File no: MC-15-909
SSD-8375

5 December 2019

**Notification of exhibition of a State Significant Development Application for the
Pick n Payless Metal Recovery and Recycling Facility located at 57-69 Tattersall
Road, Kings Park**

Plan No.
CC160136-1-101

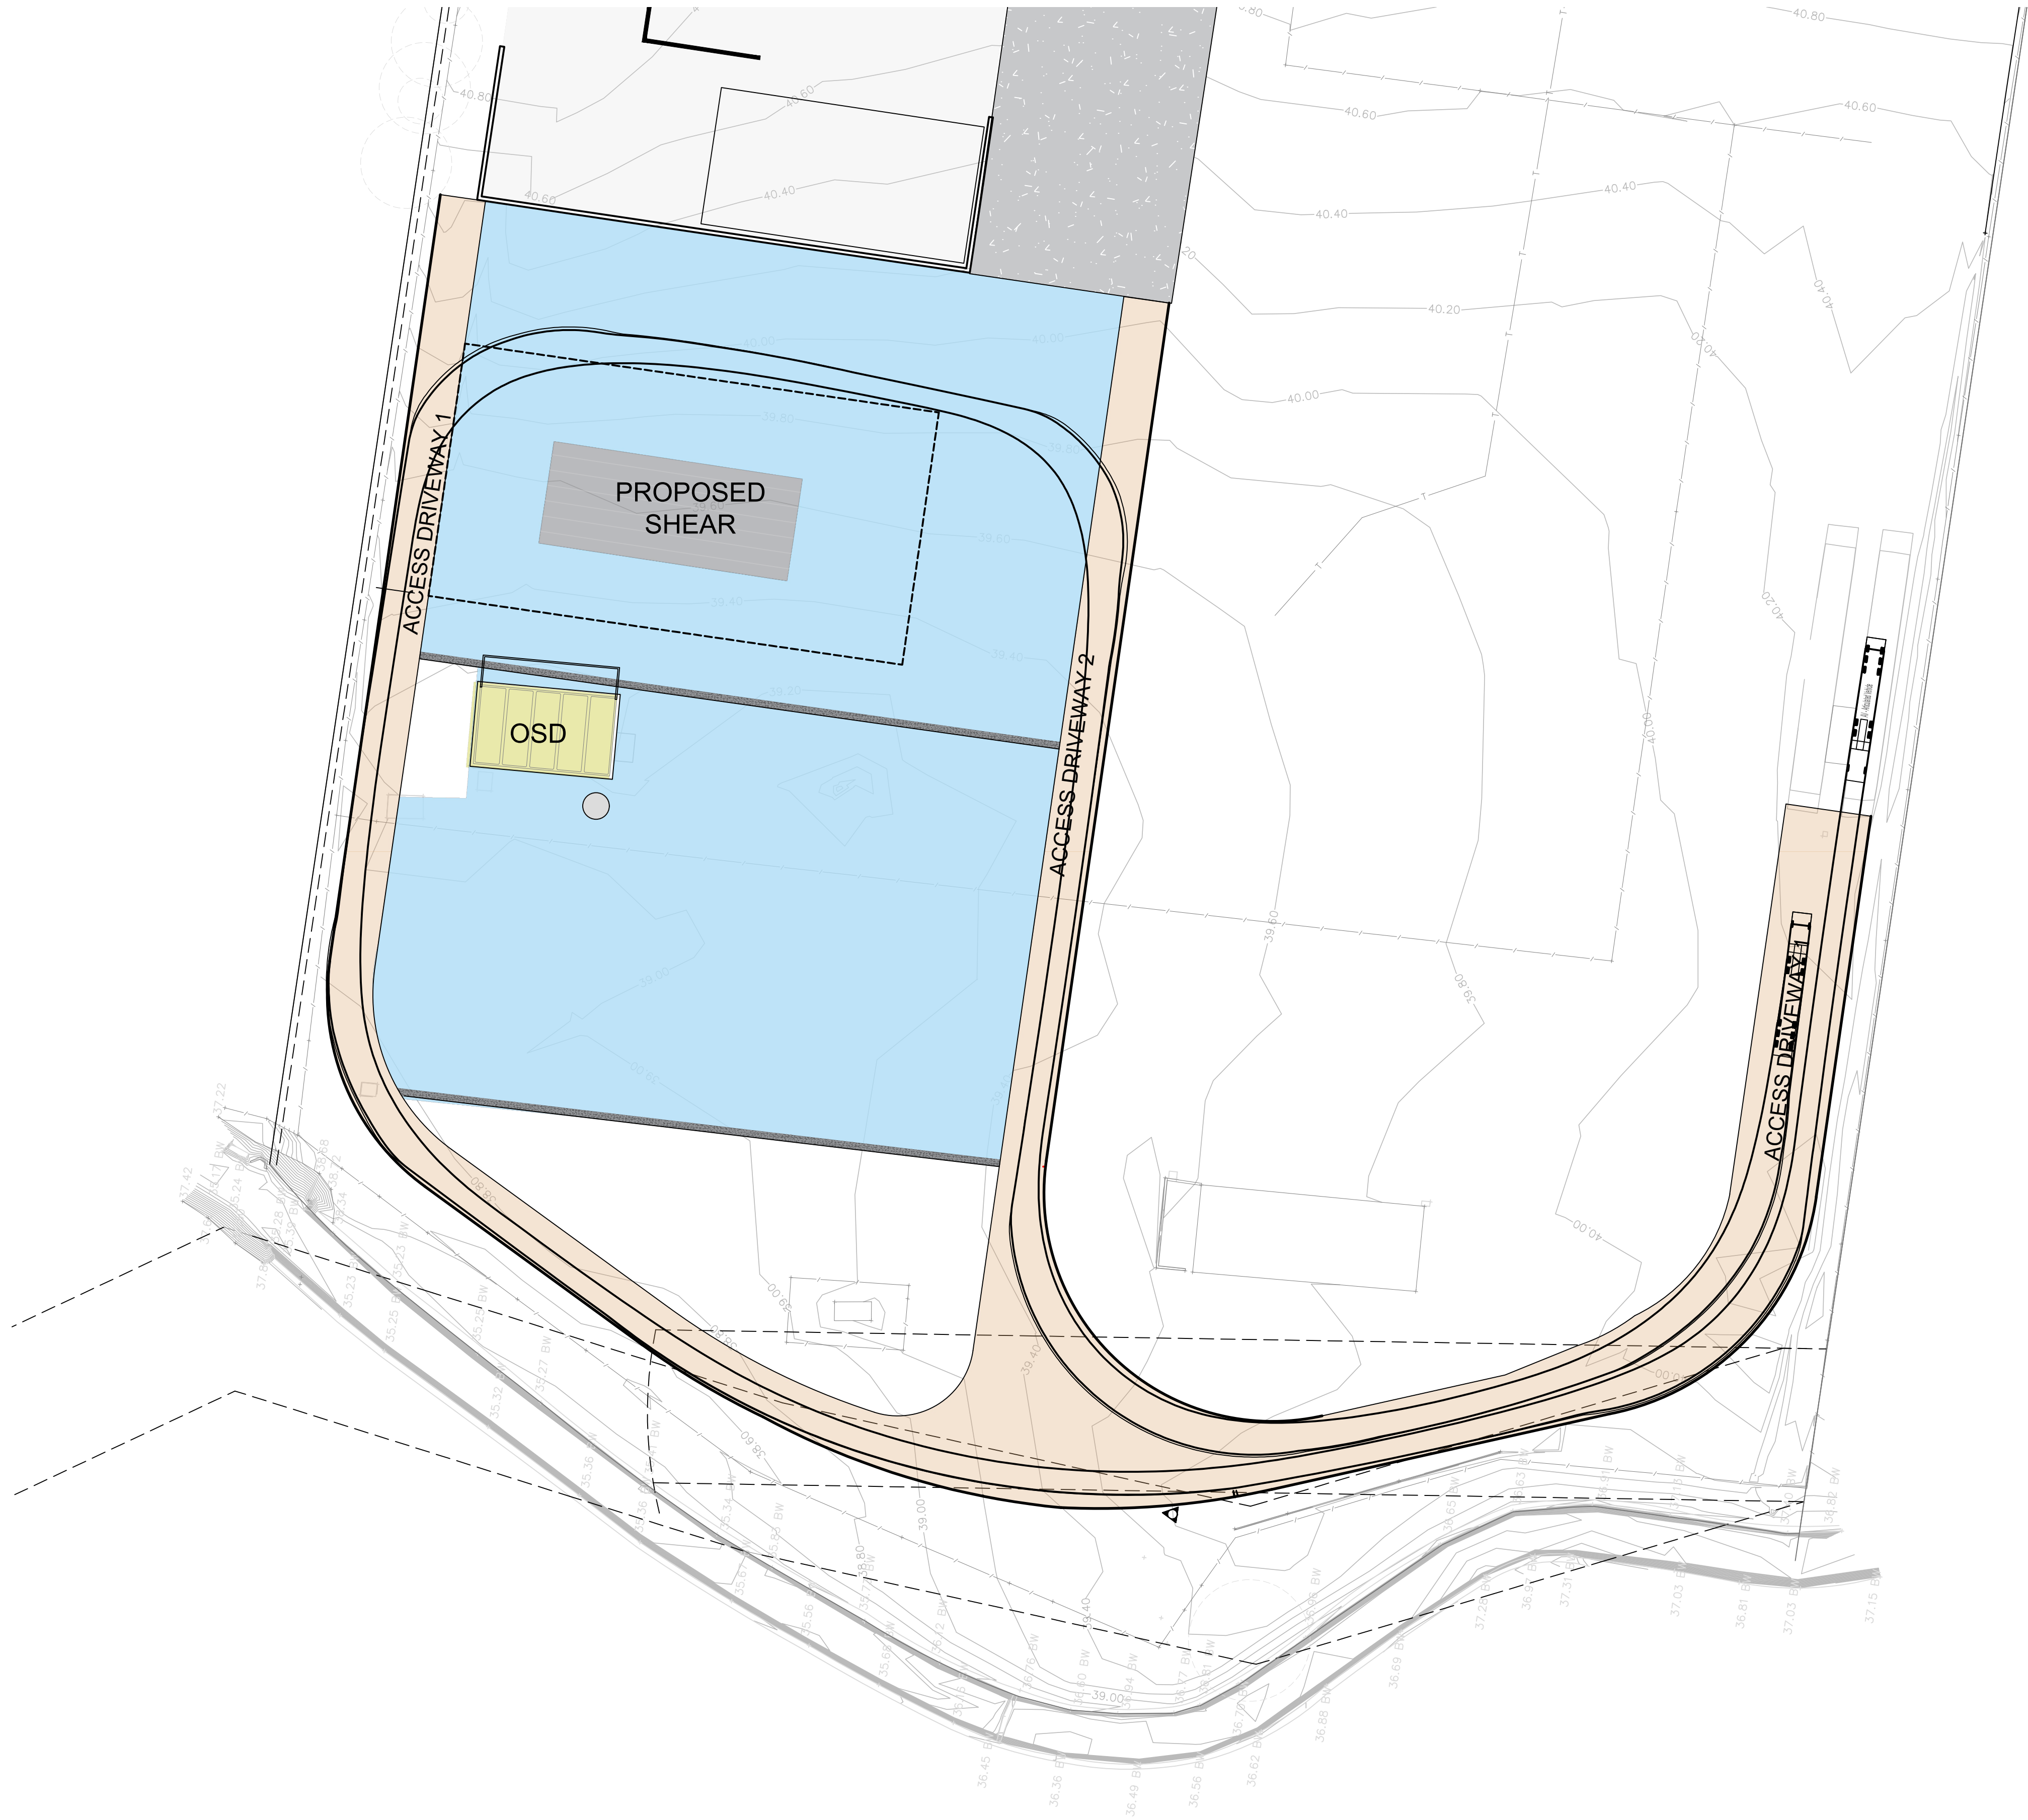
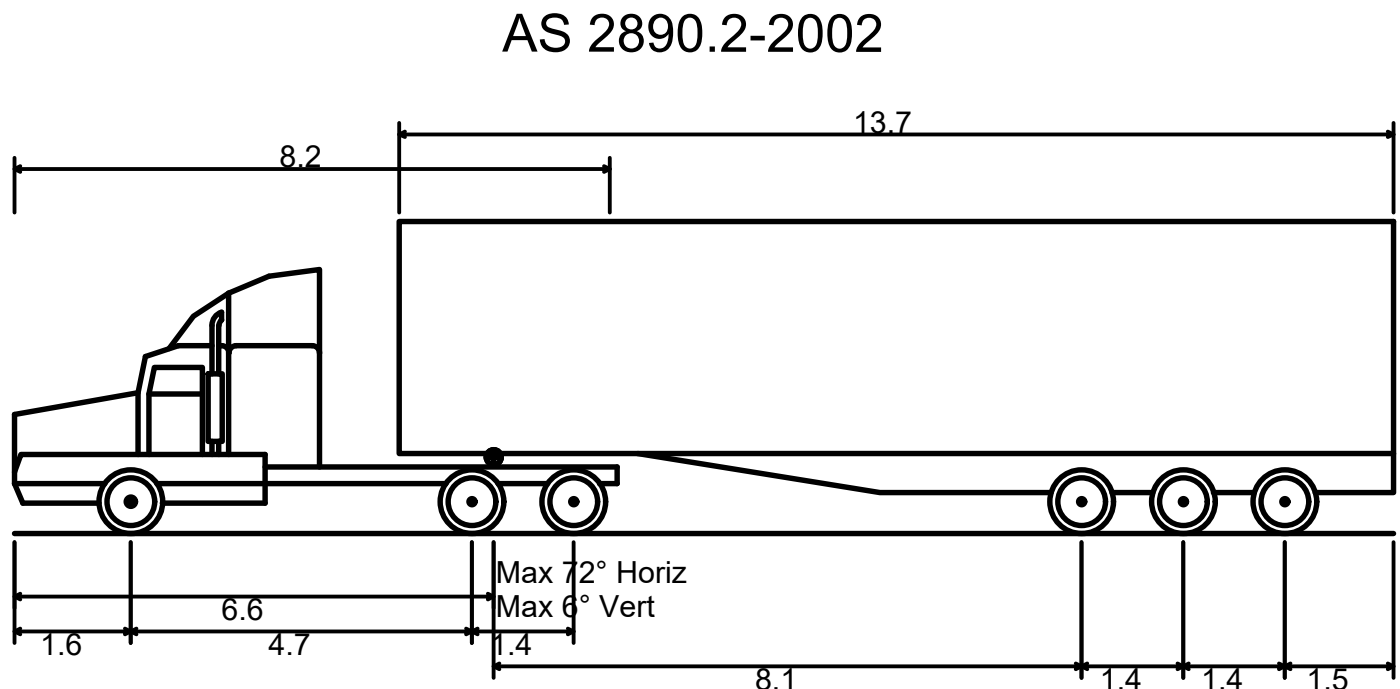
- vii. On drawing 101 (A) delete the Jellyfish filter as full on-lot water quality treatment is NOT required.
 - viii. Provide details of the Gross Pollutant Trap (GPT) such an online Stormceptor prior to all discharges to the creek or OSD tank and sized to treat a minimum 2 EY flow considered as 75% of the 1 EY flow targeting gross pollutants and hydrocarbons. Diversion weirs for off line treatment systems are not permitted.

- xi. On drawing 101 (A) raise HW10 by a minimum of 0.9 m to reduce the restriction of high water levels in the creek on the OSD system operation. Consider adjusting the orifice centreline so that the orifice inverts just drain from pit to pit.

ACCESS DRIVEWAY 1 LONGITUDINAL SECTION CH 0 - CH 270

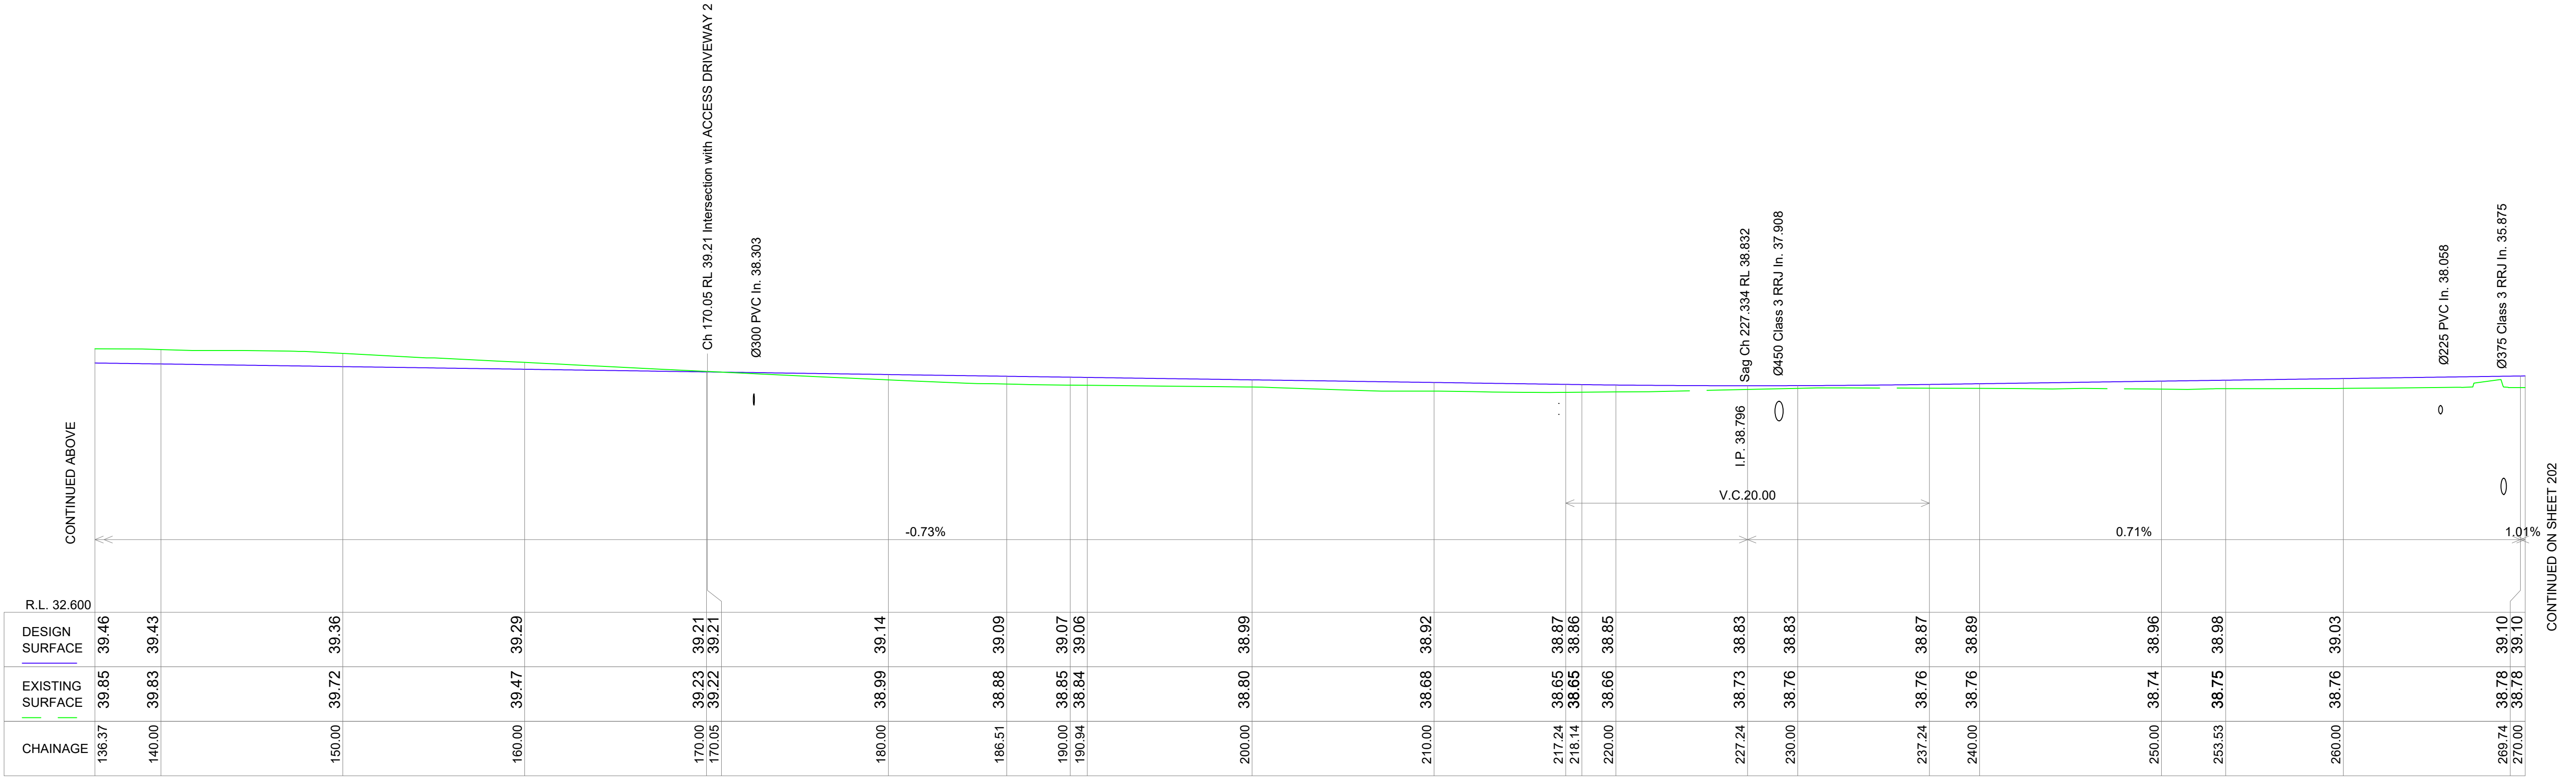
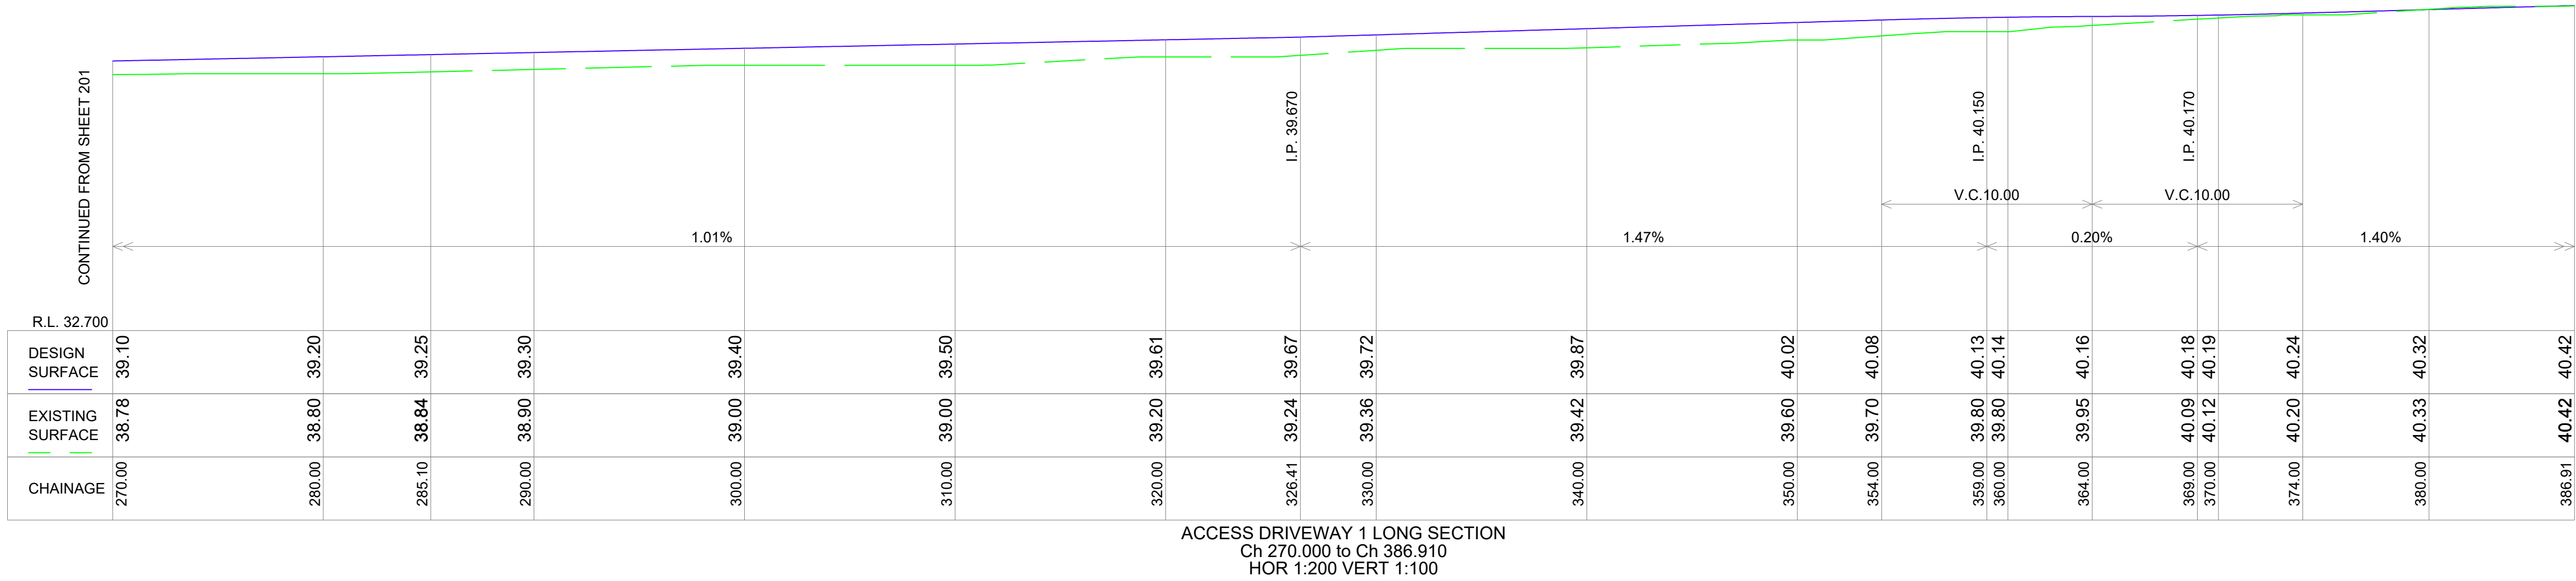
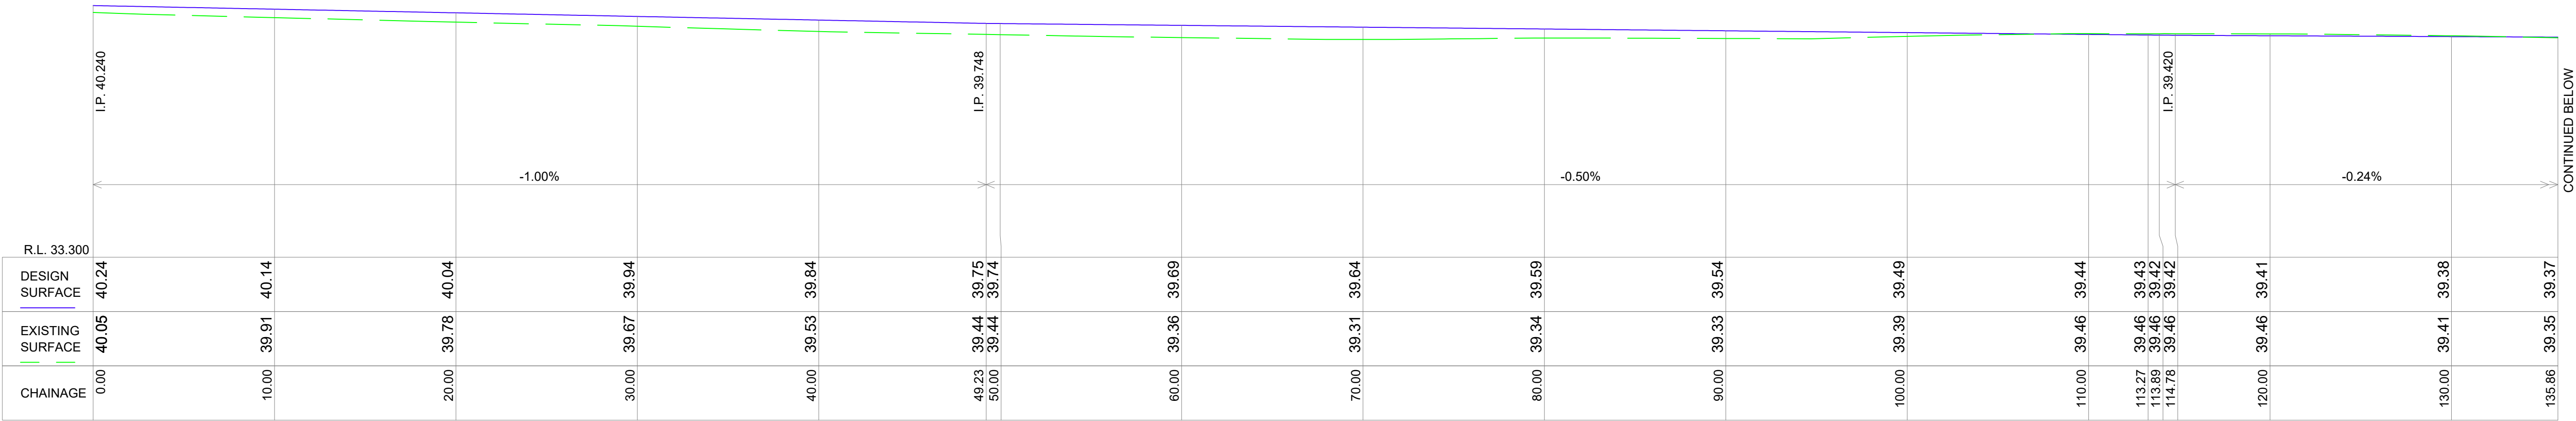
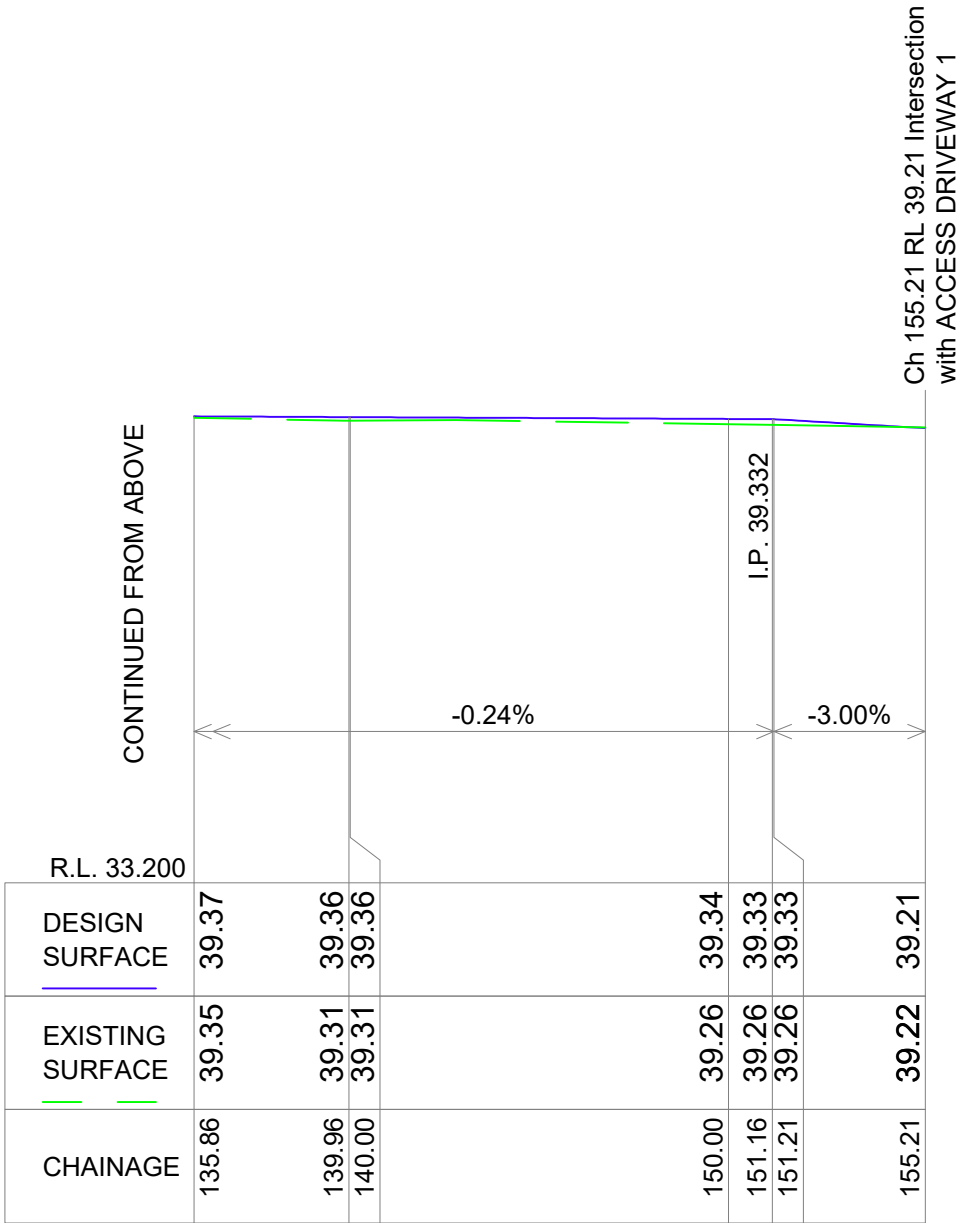
- c) The perimeter access roadway is well within the 1% AEP flood zone. Significant sections of the new roadway have been constructed above natural ground levels. Consider lowering the perimeter access roadway levels adjacent to the upstream property to be at or below existing ground levels.
